From: Amanda Scholes on behalf of Planning.Responses
Sent: 01 December 2021 09:56
To: Planning Scanning
Subject: FW: Planning Consultation on: P/156/21/DOC

Engineers Comments Regarding Condition 10

Application No: P/156/21/DOC
Registered: 8th November 2021
Site Address: Land South of Summer Lane and West of Pagham Road and West of Pagham Road Pagham
Description of Works: Approval of details reserved by condition imposed under ref P/140/16/OUT relating to Condition Nos 10 - surface water drainage and 13 - foul drainage system.

Drawing Status	DRAFT		
Client	Foreman Homes		
Project	Land at Summer Lane Pagham, West Sussex		
Drawing Title	Proposed Impermeable Area Southern Parcel		
Scale	Date	Drawn By	Checked By
1:750	Nov 21	DJL	MJA
Drawing No.	D1915-PL400		Rev.
		A

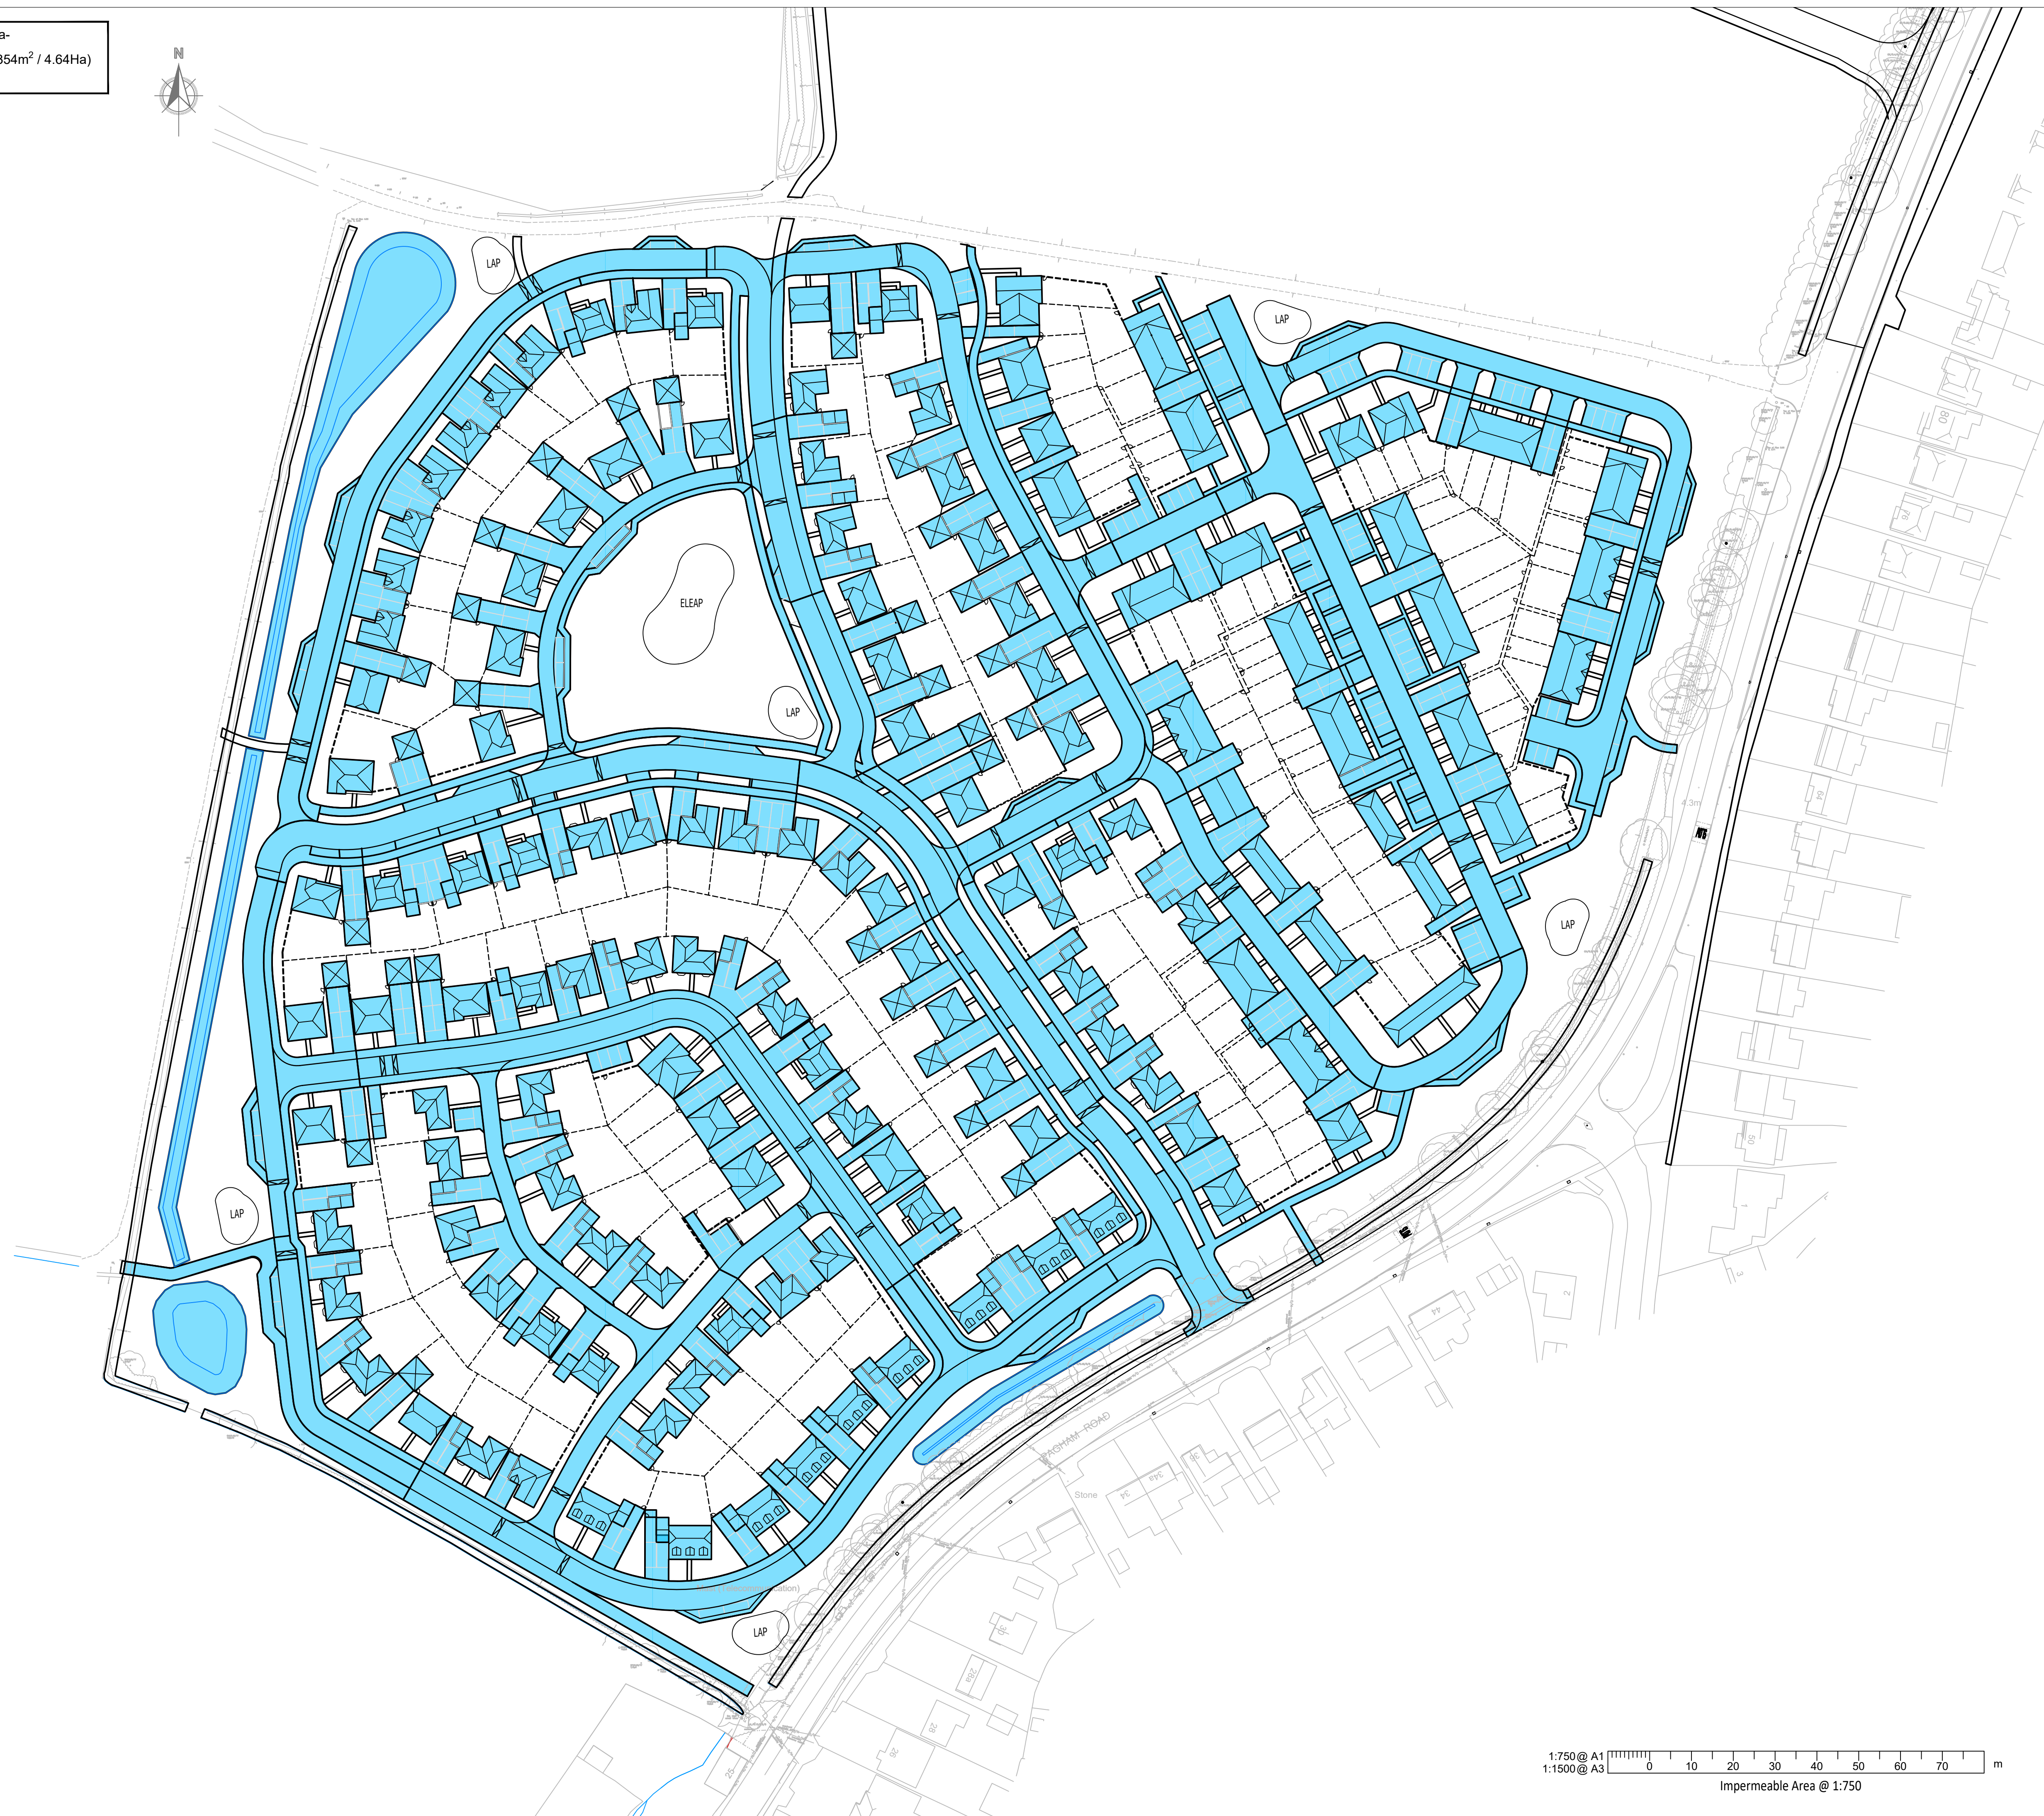
1. The proposed discharge rates are too high. The calculation of discharge rates should be based upon the positively drained area. If 3.5l/s/Ha is accepted then we believe this would give discharge rates of 16.3 l/s and 9.6l/s from the southern and northern catchments respectively, rather than the 34l/s and 22l/s proposed. Revised greenfield runoff rate calculations should be supplied.
